Application number: 2024/93234	
What is the application for?:	Erection of detached dwelling with integral garage (within a Conservation Area)
Address of the site or building:	adj, Broadyards, 289, Oxford Road, Gomersal, Cleckheaton, BD19 4JP
Postcode:	BD19 4JP

Type of comment: An objection	
Do you wish your comments to be published on the website anonymously?	Yes
I object to the proposed development, 2024/93234, and make the following observations: Scale: The proposal is inappropriate and significantly larger than previously approved, expired plans. Previous ridge height was 7m, new plans show the ridge as 9m, 2m higher. The expired approved 2006/95233 was less dominating in mass, shape and footprint, particularly the amount of 2 storey accommodation. The proposal is similar in mass to the withdrawn application 2006/92897 The roofs of withdrawn 2006/92897 and the approved 2006/95233 were both hipped in design, in-keeping with the design of Broadyards and other neighbouring historical buildings. The design of the proposed dwelling (2024/93234) has no hipped part to the roof shape, therefore inappropriate and increasing its dominance. Previous plans showed a double garage with singl

Title
Proposed Plans and Elevations

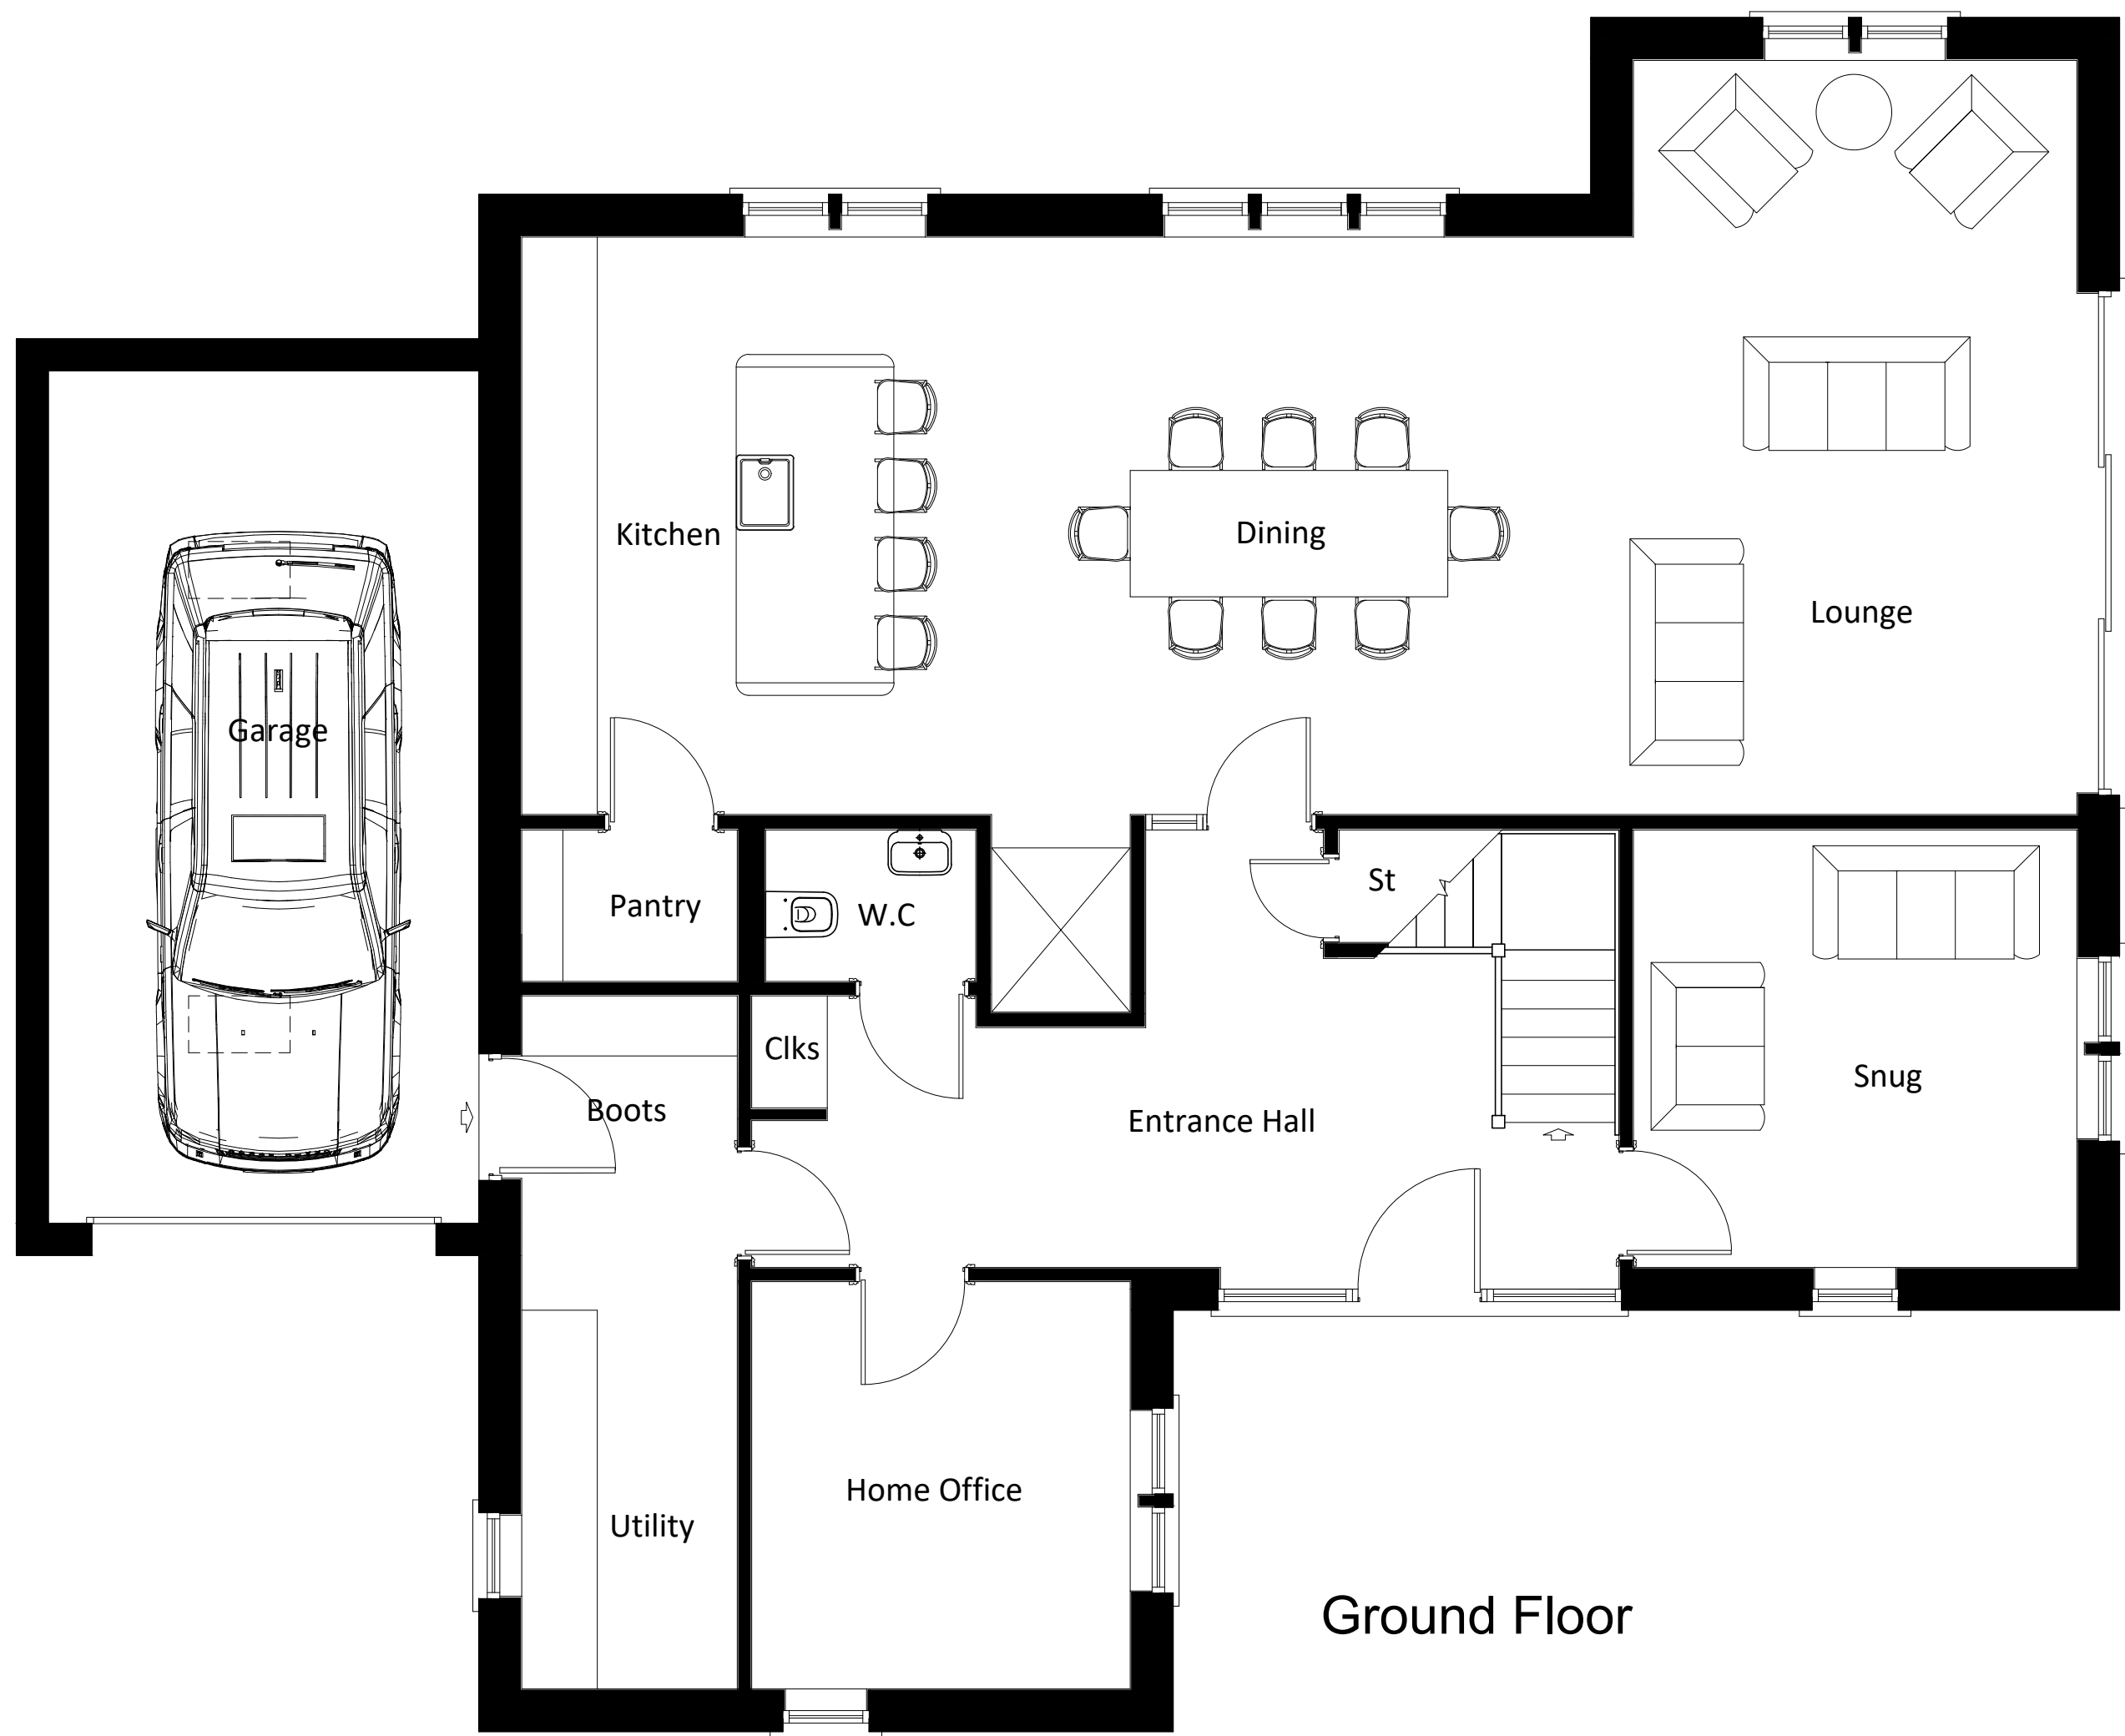
North elevation gable provides unnecessary extended seating to large main lounge, and extends master bedroom ensuite and walk-in wardrobe. This increases the building's footprint and roof shape/size, compounding the loss of light and intensifies the building's dominance.

Overlooking: First floor guest ensuite bedroom (4) and bedroom 3 overlook historic properties to the north.

Feature Entrance

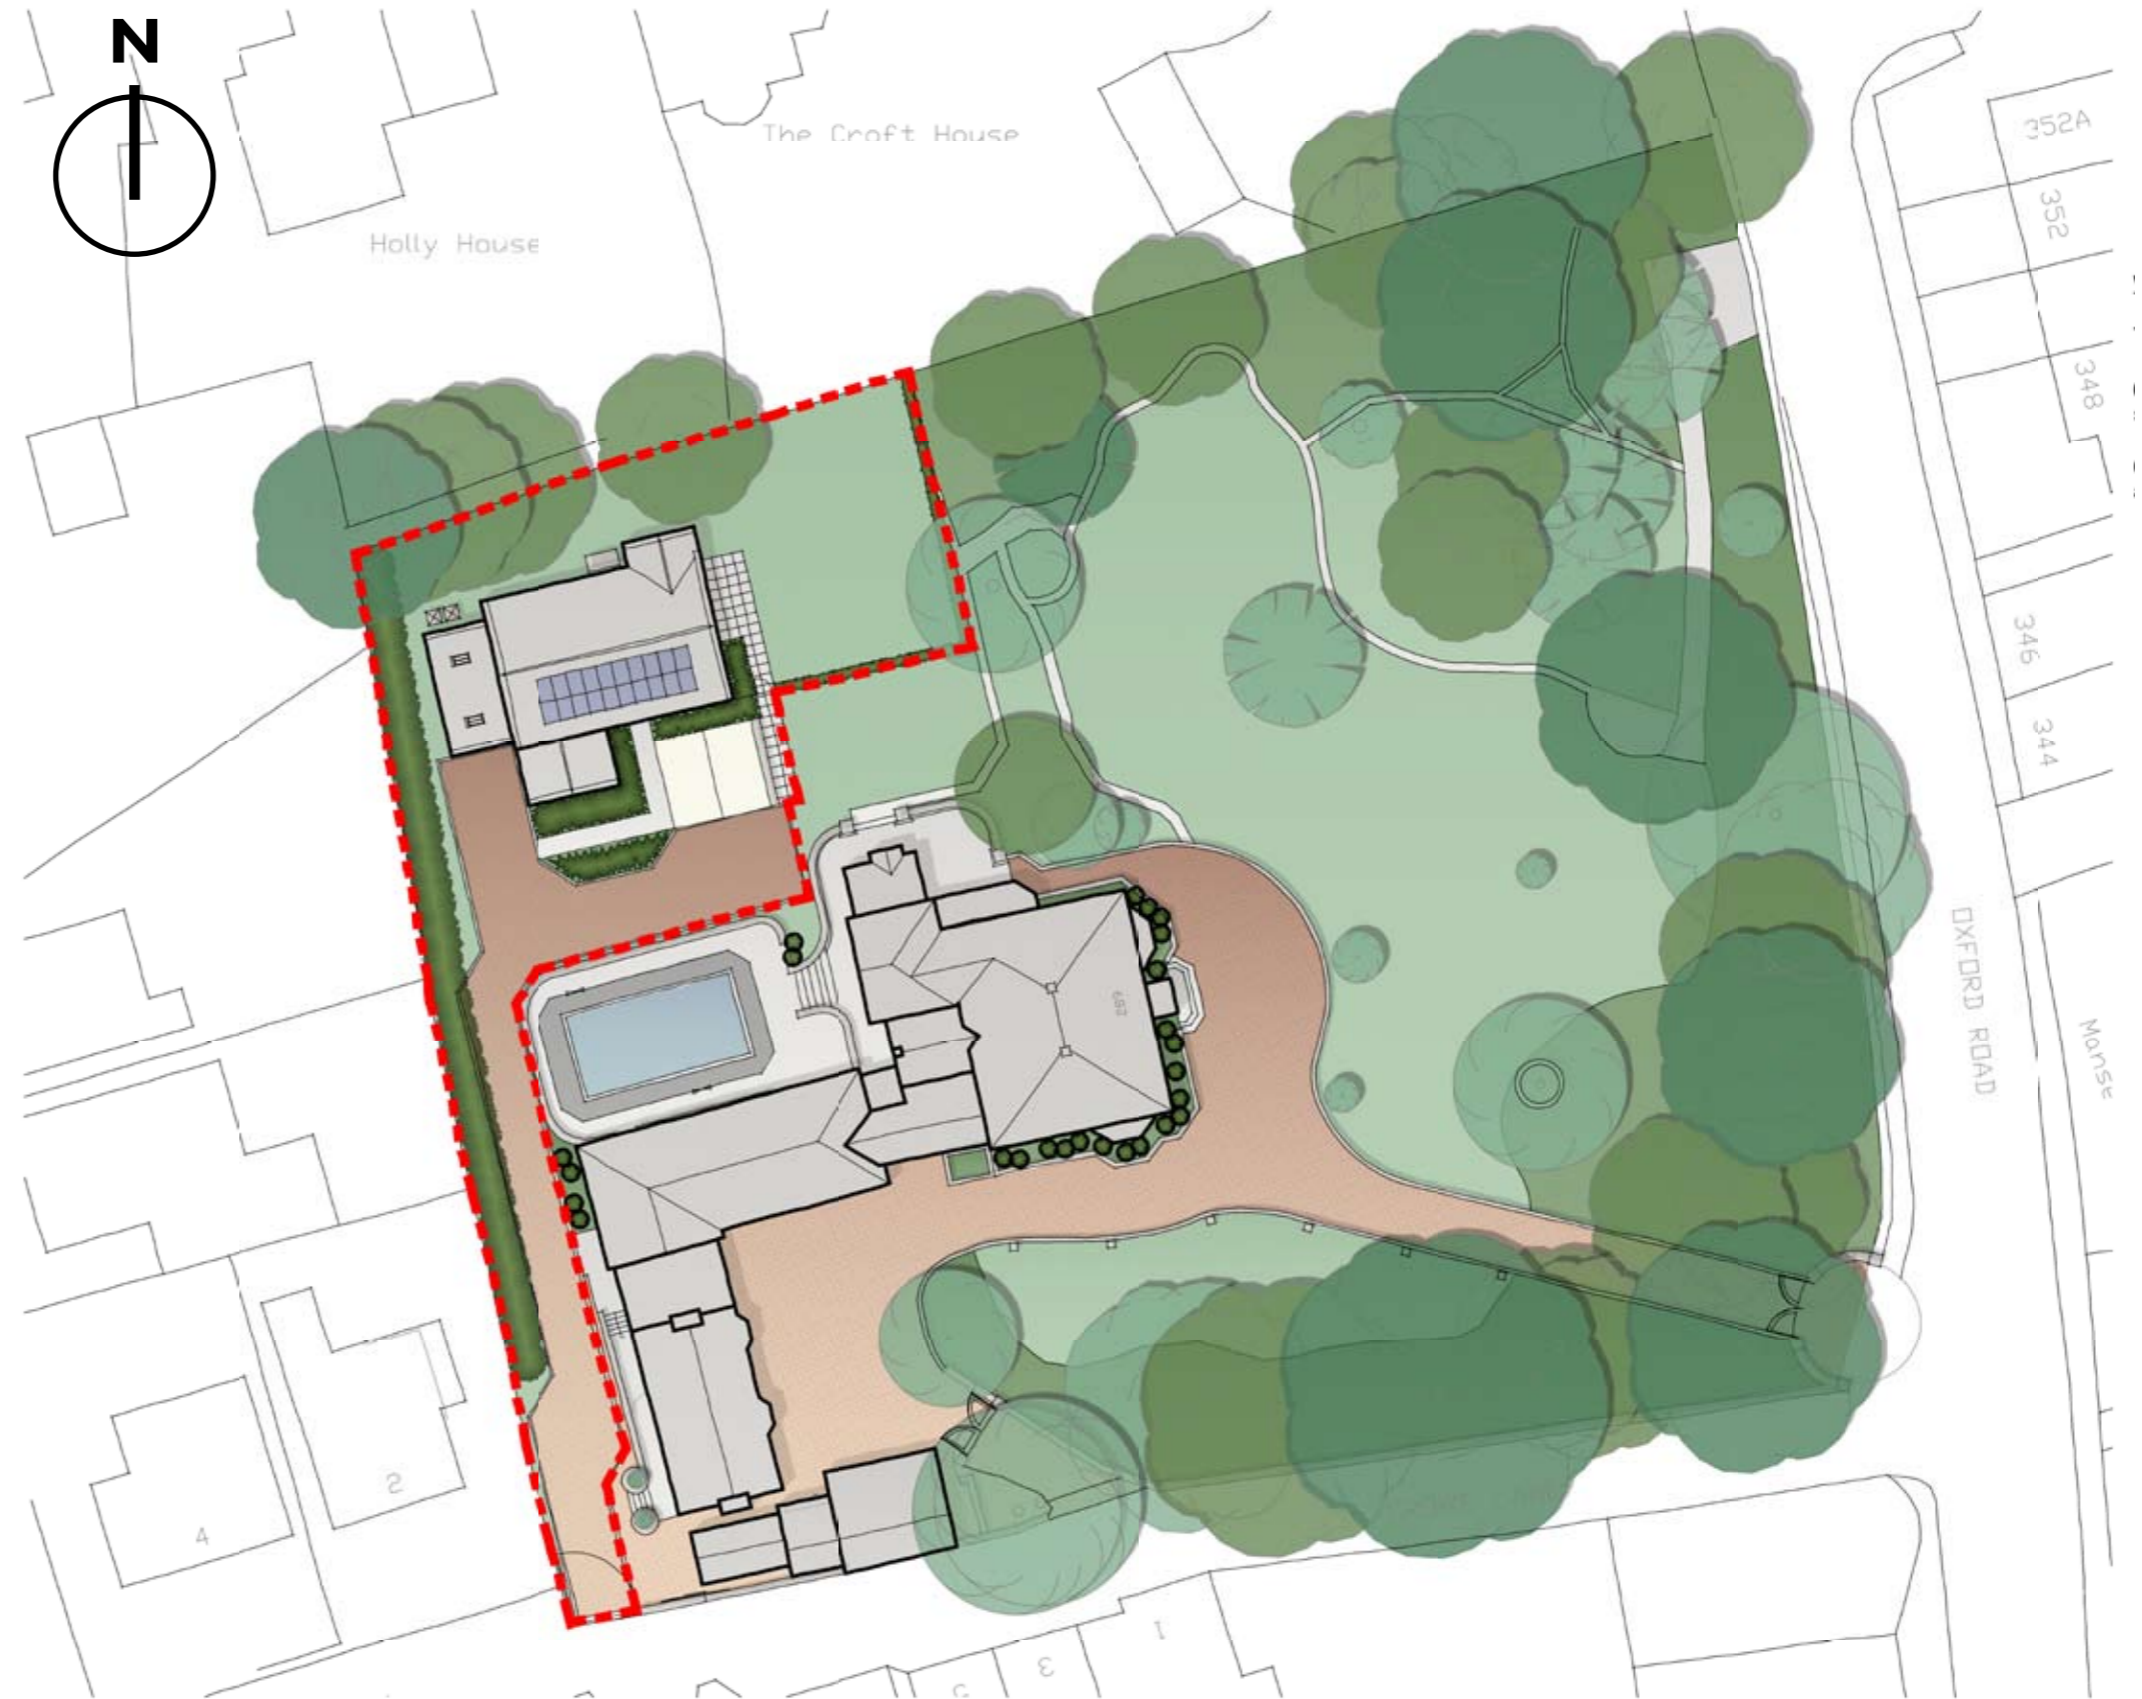
P12, D&A, Identity: The proposal is not in keeping with the identity of the area, as shown by the Design Statement photos, nor is the 'feature entrance' photograph - it is not a neighbouring property, not indicative of the historic architecture and not in keeping with the site or area.
